**PUBLIC HEARING--DEVELOPMENT REVIEW BOARD
CITY OF ALBUQUERQUE**

Project# 1005450

This letter is to serve as a comment to the Development Review Board (“Board”) regarding the proposal for Project #1005450, known as Longacre Subdivision (“Longacre”). This comment reflects the shared position of individuals (“Ditch Users”) who own residential properties in the on Spur Court NW, an east-west public street which lies south of the proposed development, or on Gabaldon NW, a north-south public street which lies west of the proposed development.

Ref: DRB project #1005450
#08DRB-70504, Preliminary Plat for Longacre Subdivision

GRADING AND DRAINAGE PLAN

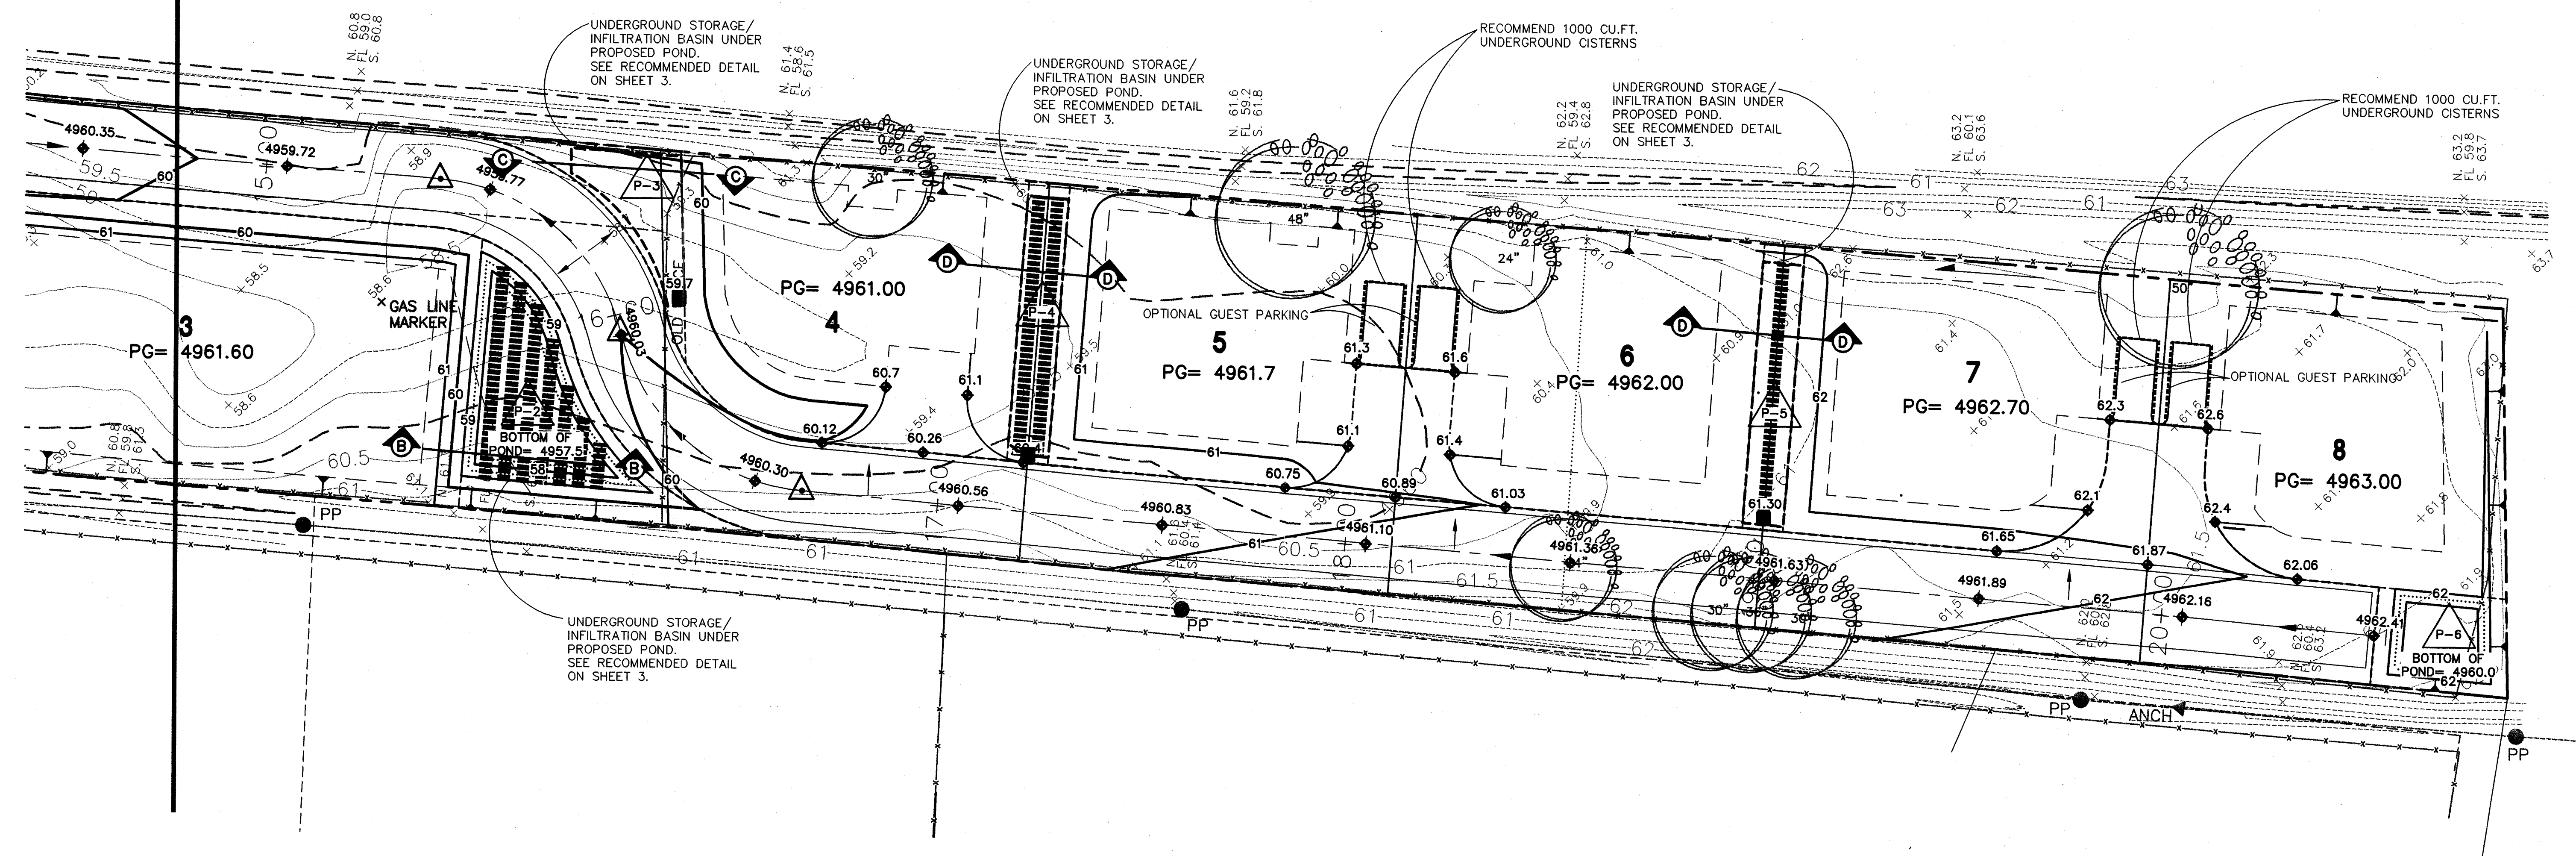
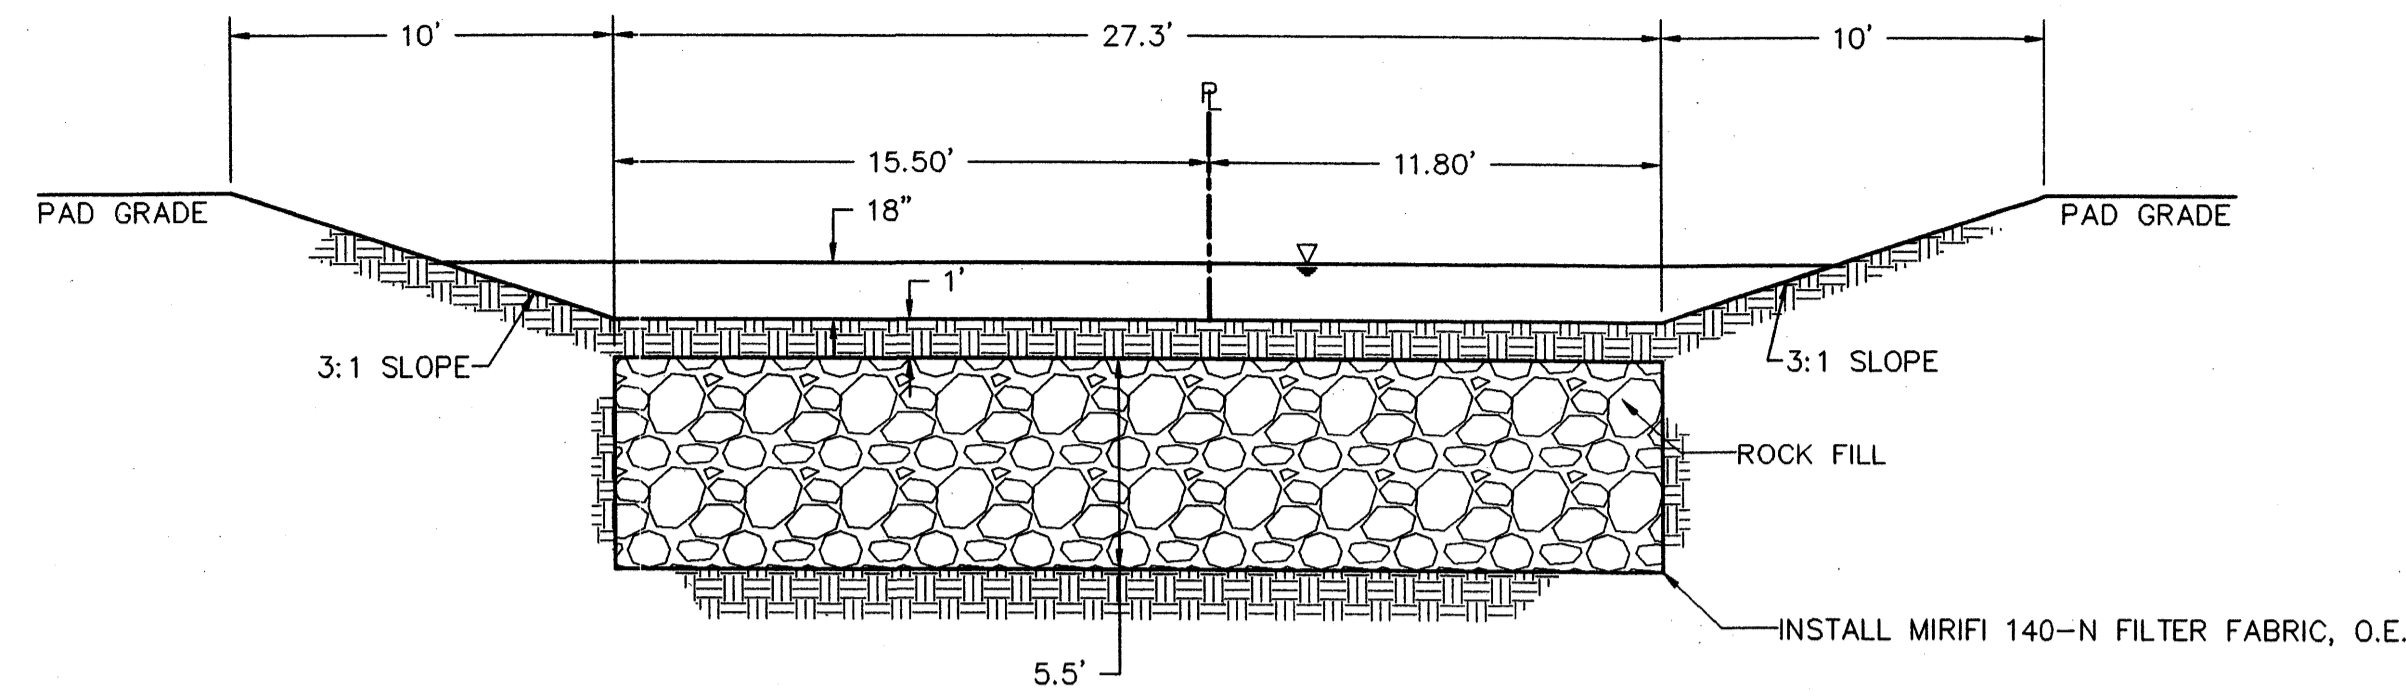
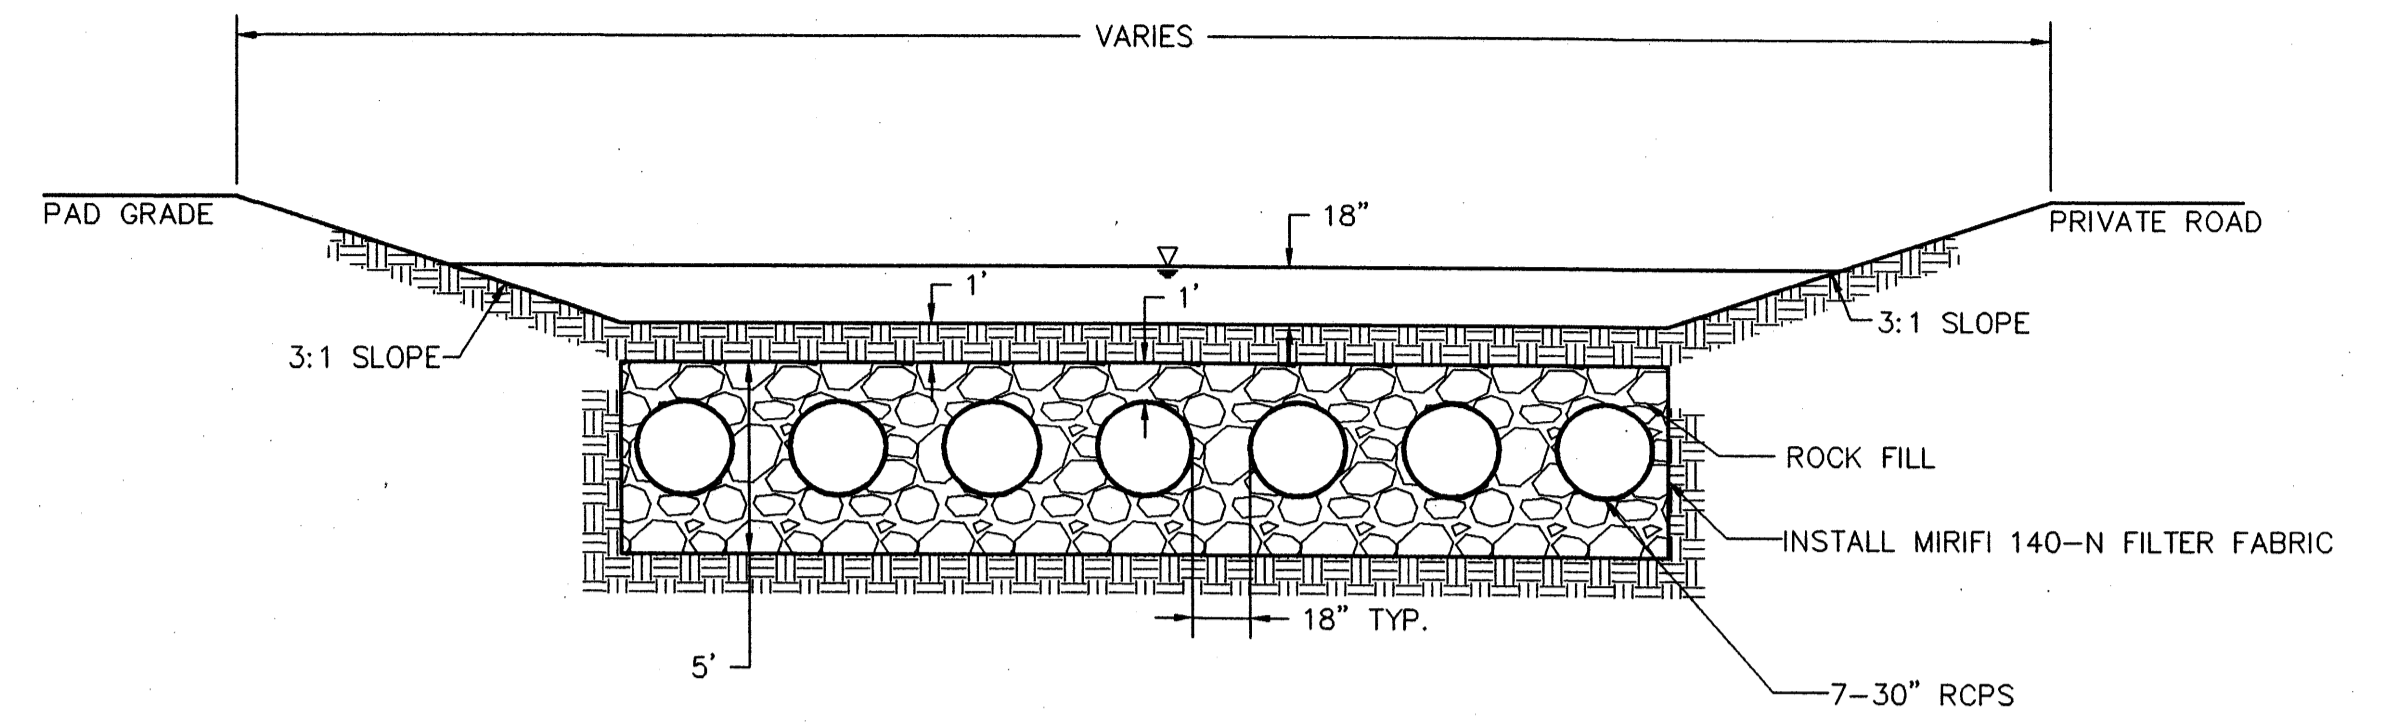
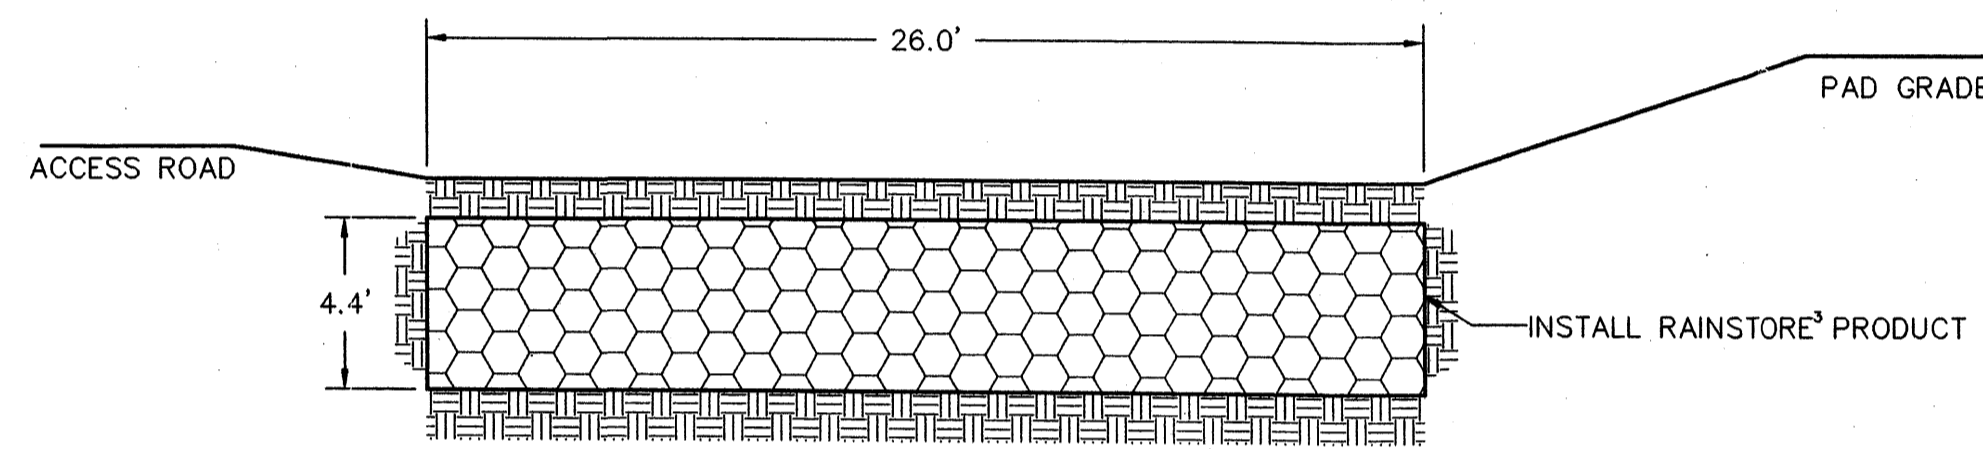
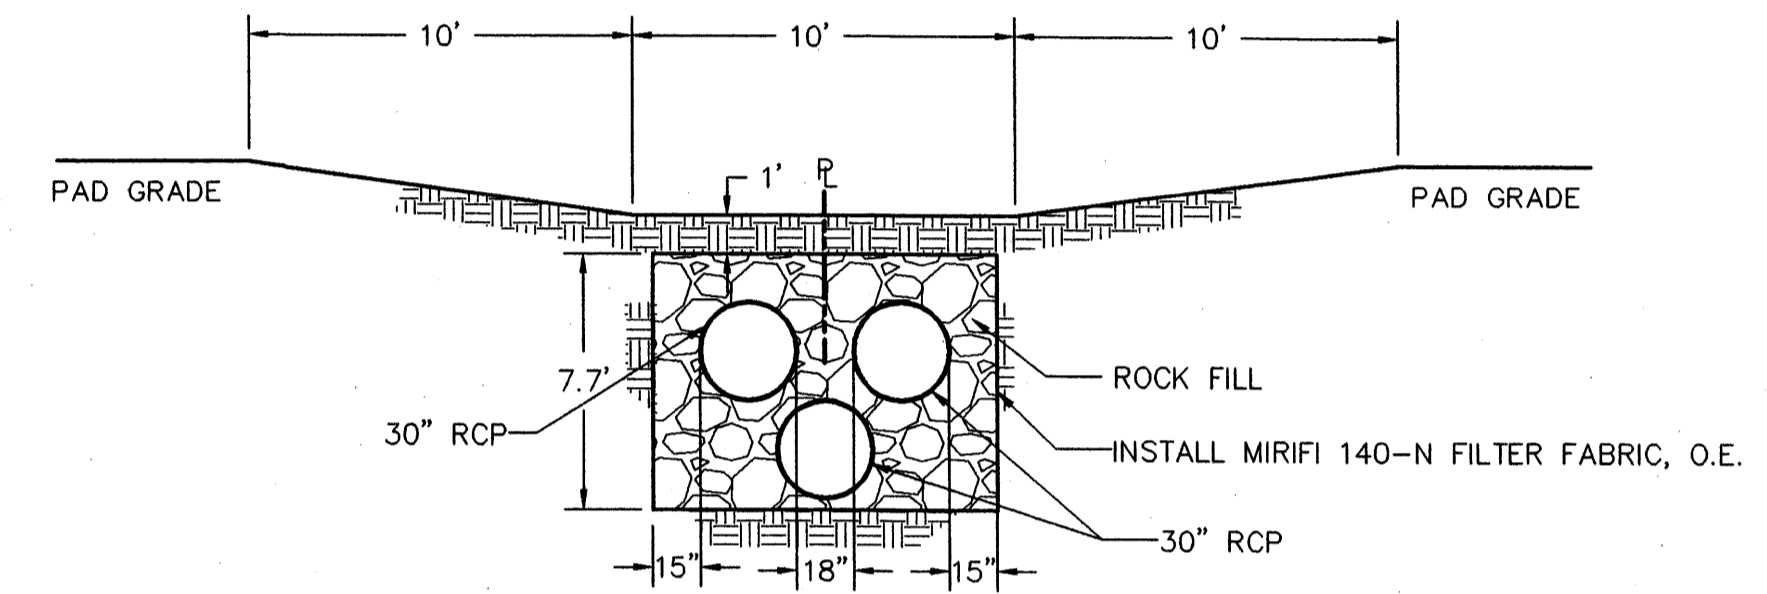
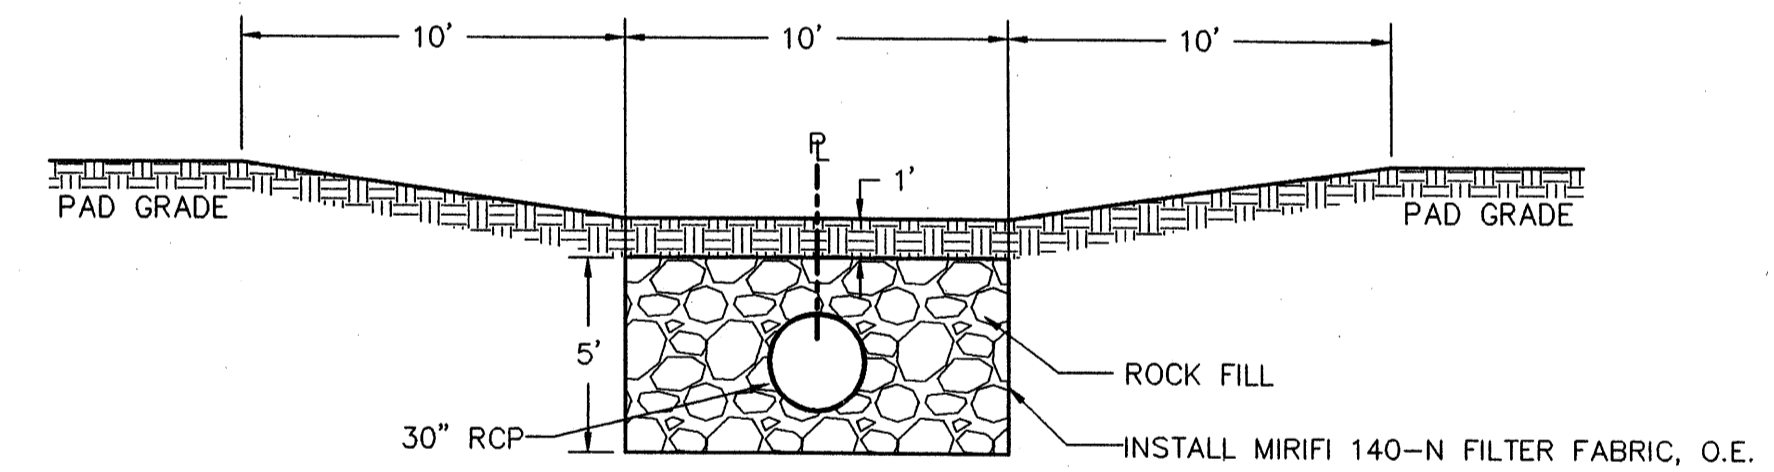
An initial concern is the apparent lack of provisions for adequate drainage of storm runoff. The proposal contains references to catchment areas between the pad sites contemplated for home construction. Assuming these catchment areas are even sufficient for the proper management of runoff water, these will likely require maintenance and upkeep over time. Such maintenance typically involves the use of heavy equipment, which would require physical access not apparent in the proposed plan. In other words, these catchment areas are simply not future-

proof because upon construction of homes pursuant to the plan, it will become extremely complicated to maintain or repair the catchment areas. The drainage design is questionable because in order to achieve the high density planned in Longacre, the planners have apparently sacrificed the necessary area which would need to be set aside for pure surface ponding remote from structures. Instead of setting aside such area, the Longacre plan relies upon immediate infiltration of runoff into underground storage volumes to handle part of the runoff. The infiltration surfaces and underground storage volumes might become clogged over time. Also, some catchments inject runoff into the ground next to houses. If the catchments clog it would be expensive to repair. If catchment flows undermine houses, it might be impractical to repair.
